Rezoning Transportation Analysis

Petition Number: 2020-057

General Location Identifier: Tax ID 11303105A

Revision Log:

Schematic Site Plan Rezoning Petition #2020-057

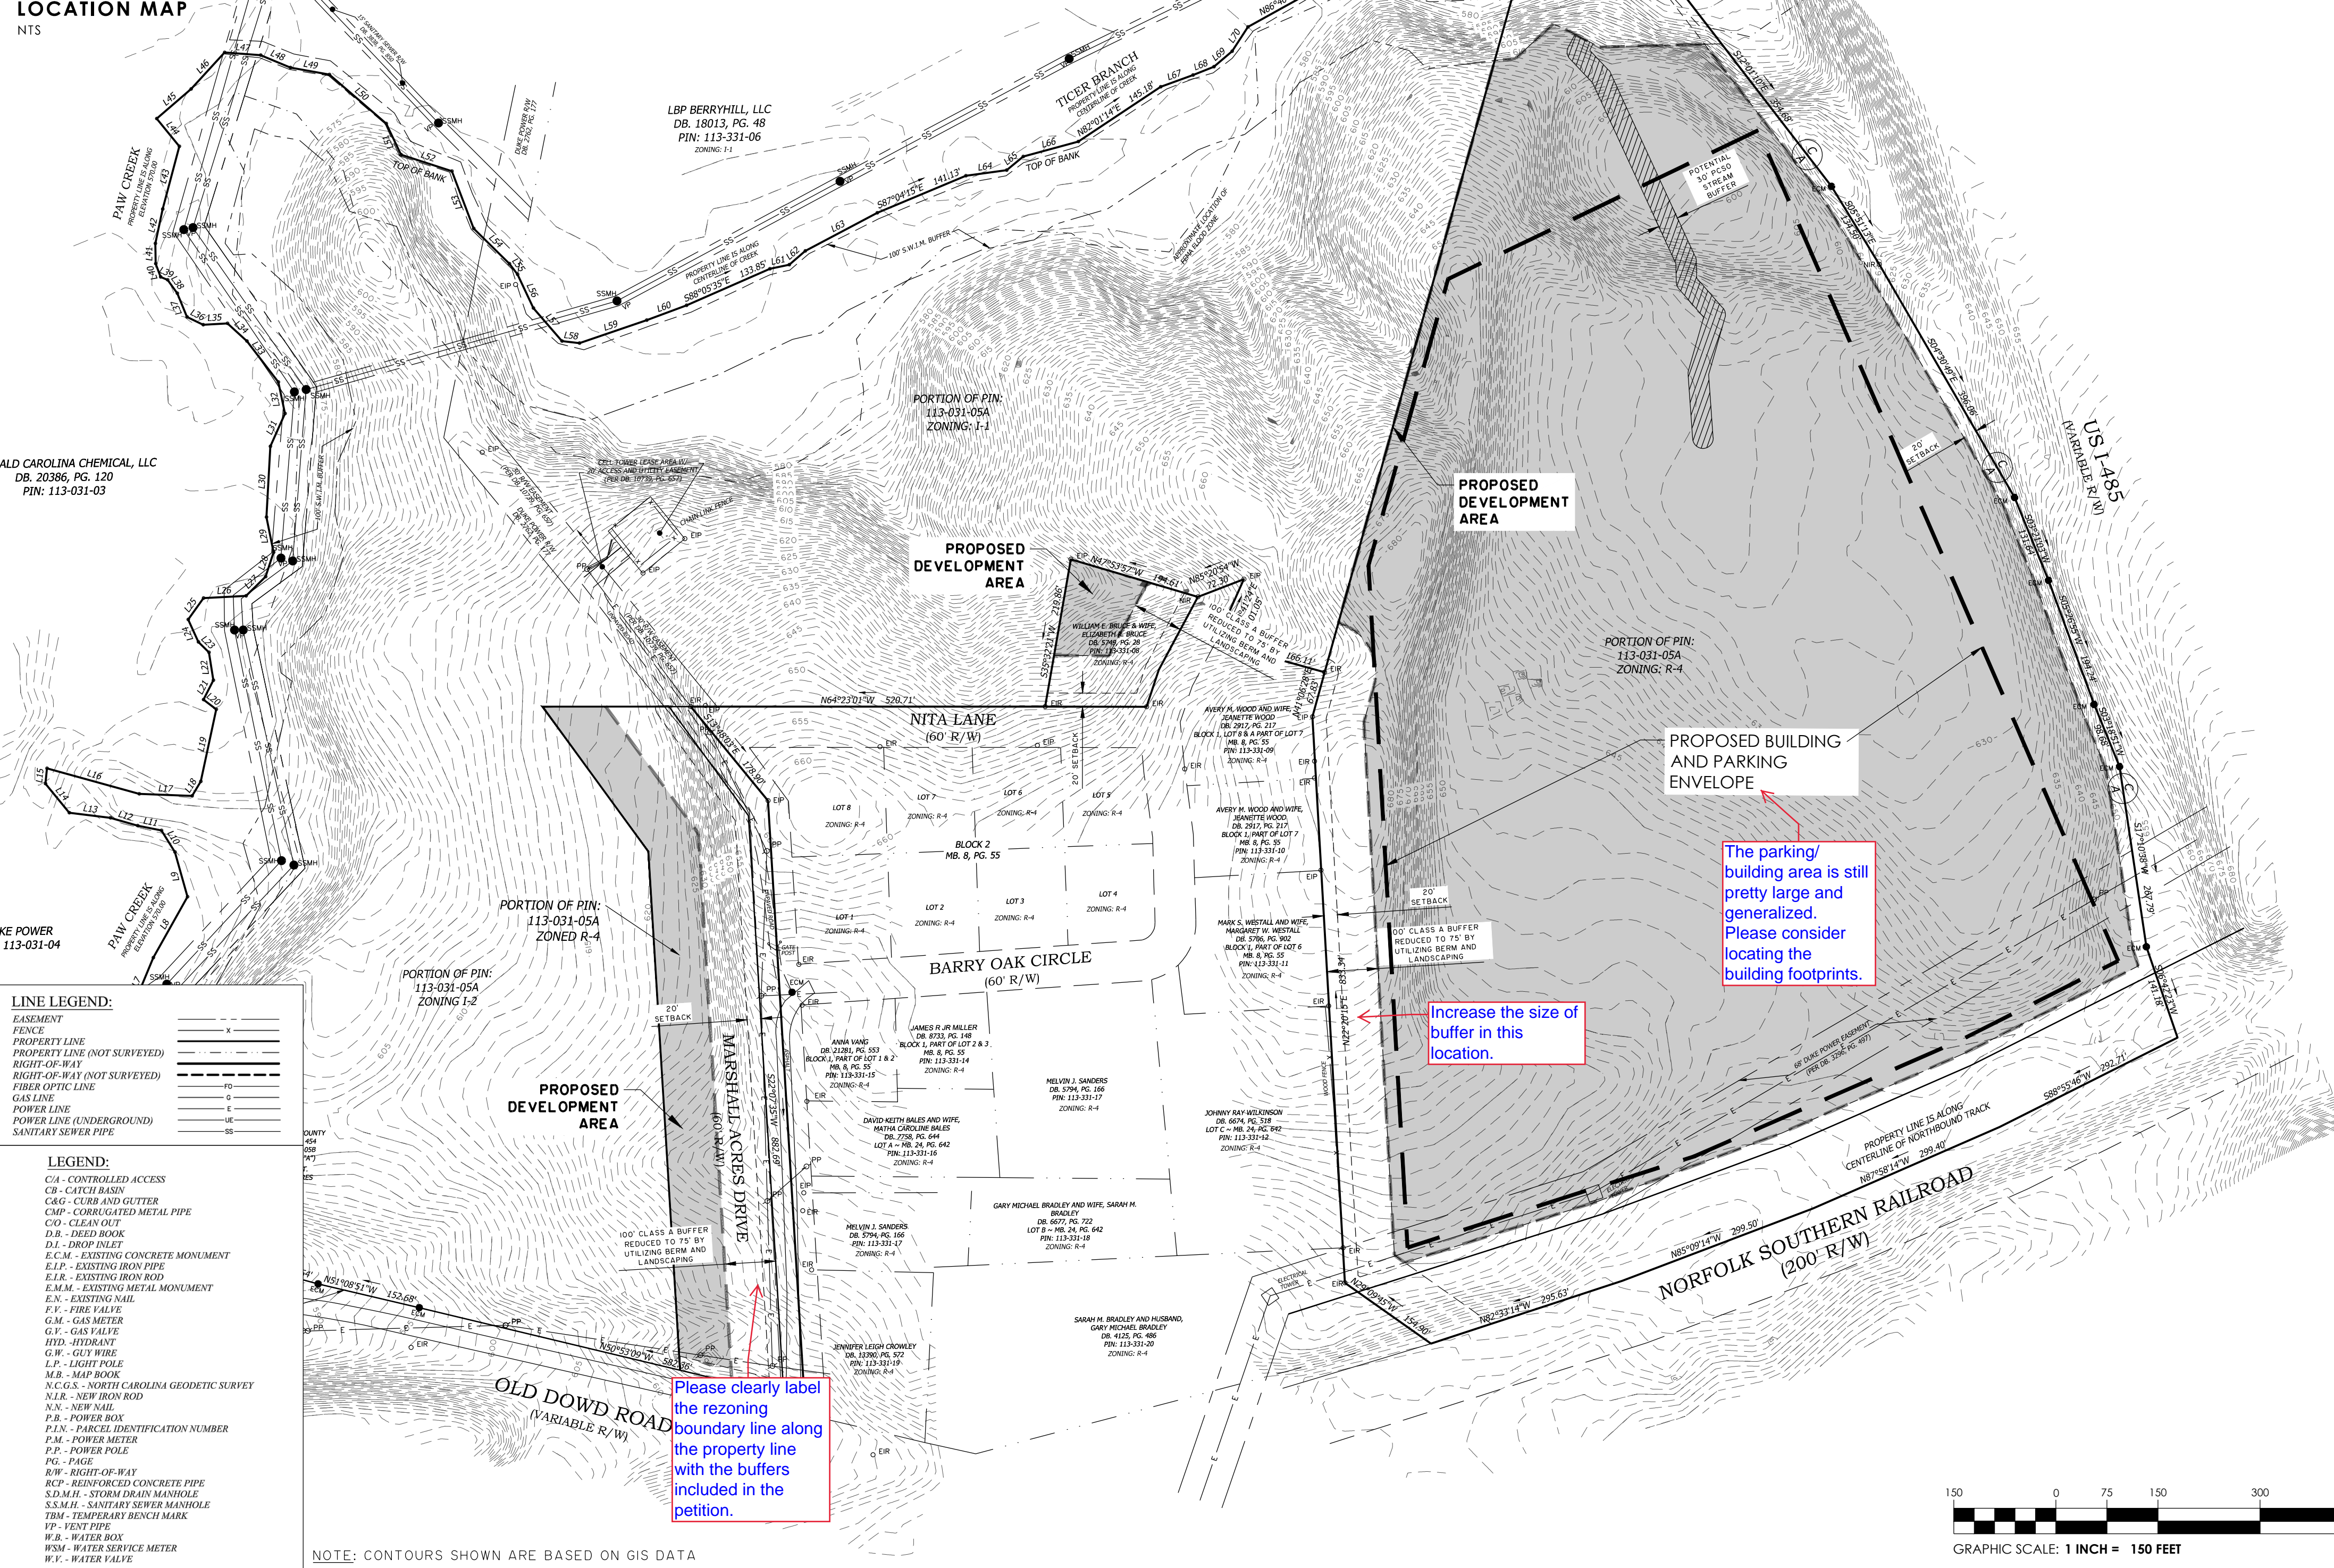
- New comment based on 6/15/20 site plan:** The petitioner should revise the site plan and conditional note(s) to reserve 120-feet of right-of-way for the Comprehensive Transportation Plan (CTP) future 4-lane grade-separated crossing for the realignment of Old Dowd Road.

- New comment based on 6/15/20 site plan:** The petitioner should revise the site plan and conditional note(s) to show the proposed access(es) to the site. It is not clear if the petitioner is proposing to use Marshall Acres Drive as the access, or if there would be an access parallel to it, or something else entirely. Comment #4 below will still apply to any new access(es) regardless of location.

- Outstanding** The petitioner should revise the site plan and conditional note(s) to construct right and left-turn lanes at the proposed access on existing Old Dowd Road. An internal 3-lane section should also be designed to accommodate the future realignment of Old Dowd Road.

5. **Outstanding** The petitioner should revise the site plan and conditional note(s) to commit to construct an 8-foot minimum planting strip, and 6-foot sidewalk on existing Old Dowd Road per Chapter 19 of the City Code. The site plan should label and dimension both items from the edge-of-pavement/shoulder and road centerline.

6. **Outstanding** The petitioner should revise the site plan and conditional note(s) to commit to construct an overland connector along the future Paw Creek Greenway on existing Old Dowd Road to meet the City of Charlotte BIKES Policy and Greenway Master Plan.

7. **Outstanding** The petitioner should revise the site plan and conditional note(s) to confirm whether the proposed development will consist of one or two buildings, to determine applicability of the Subdivision Ordinance.
